CITY OF ALBUQUERQUE

April 6, 2023

Re: Fireflower
2120 Eubank Blvd. NE
Traffic Circulation Layout
Engineer's Stamp 03-14-23 (H21-D056)

**TRAFFIC CIRCULATION LAYOUT PLAN**

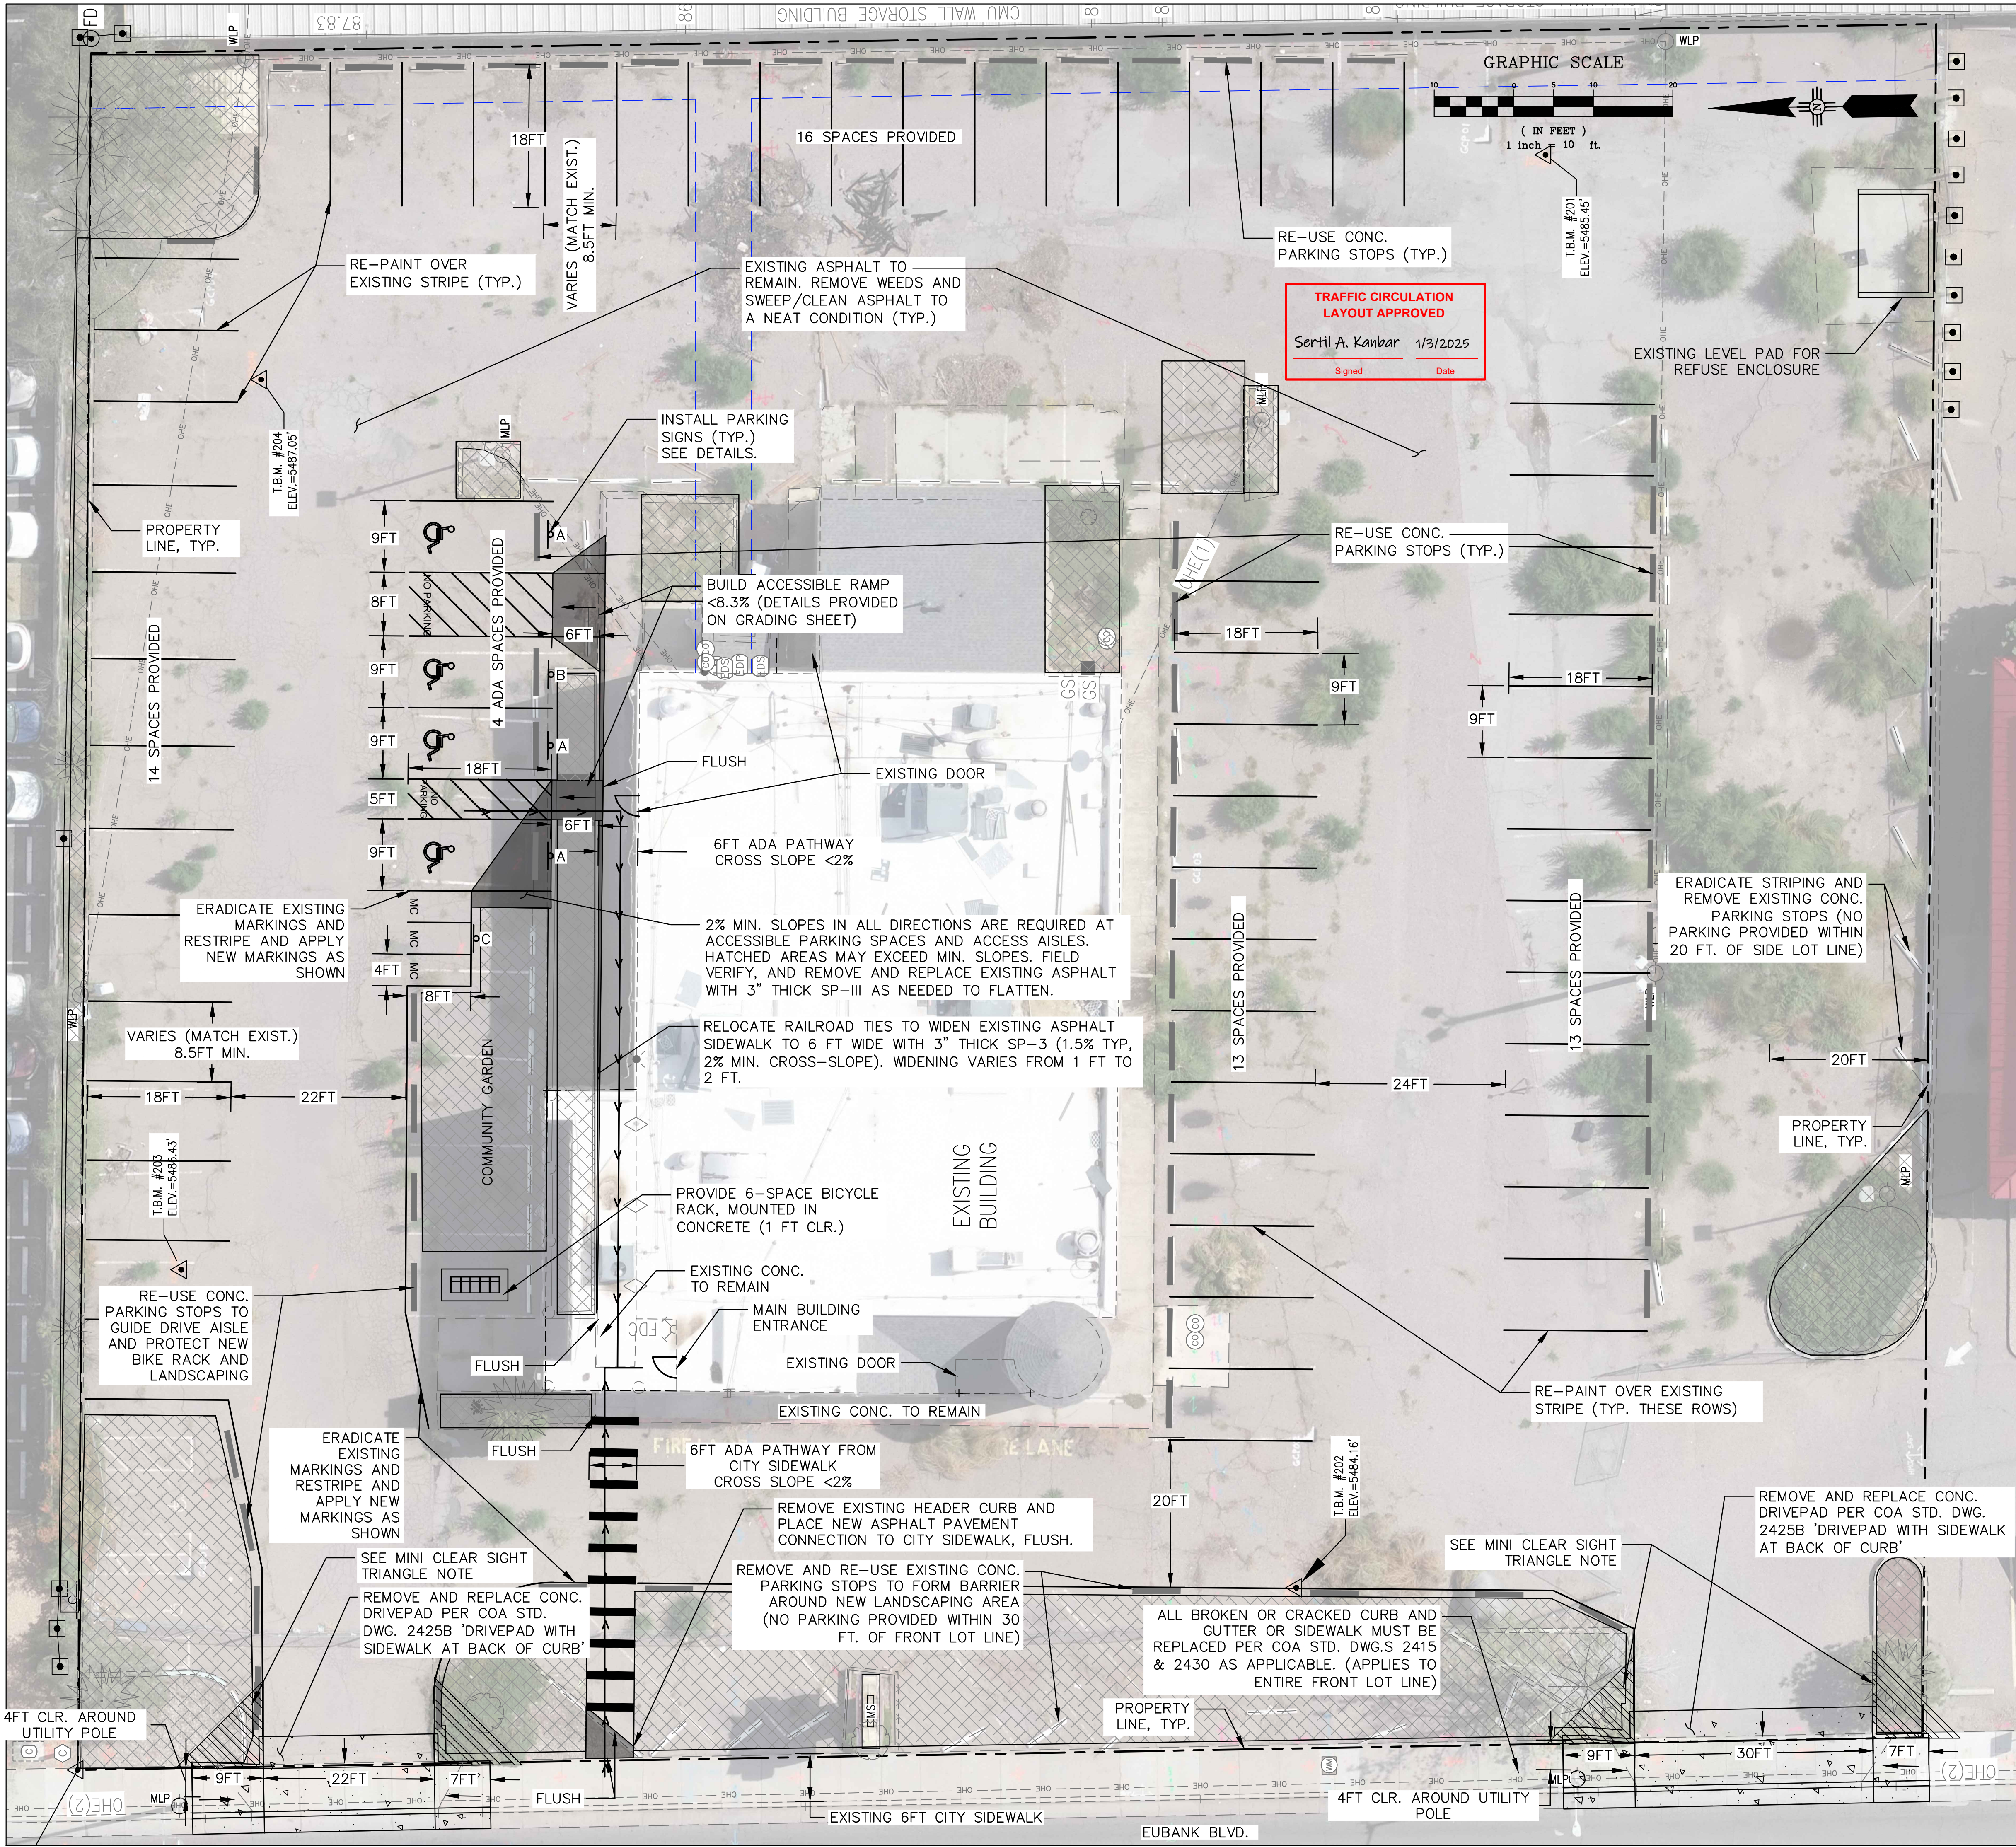
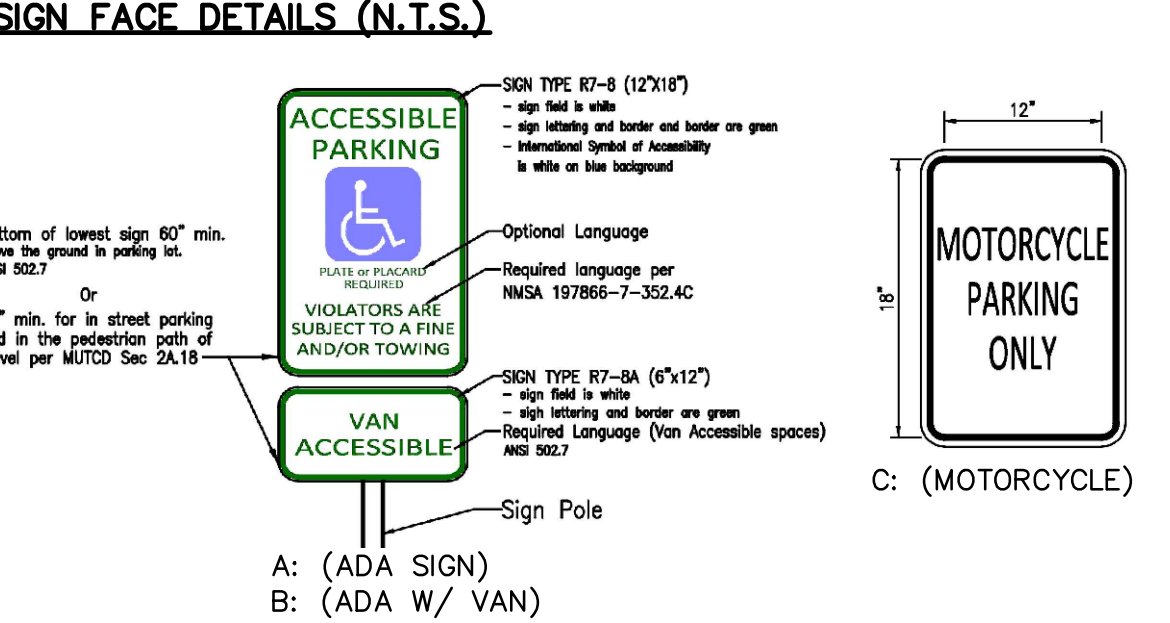
1. Please provide ADA compliant driveway accesses. Suggestion: provide a sidewalk taper per COA std dwg 2425B.
2. Define ADA pathways by form the public sidewalk and from the ADA aisle to the building entrance, by labeling of ramps or flush pavement.
3. Please provide ADA ramp details, if any.
4. The ADA access aisles shall have the words **"NO PARKING"** in capital letters, each of which shall be at least one foot high and at least two inches wide, placed at the rear of the parking space so as to be close to where an adjacent vehicle's rear tire would be placed. (66-1-4.1. B NMSA 1978)
5. The pavement marking "MC" should be shown in the opposite direction for motorcycles entering the parking space.
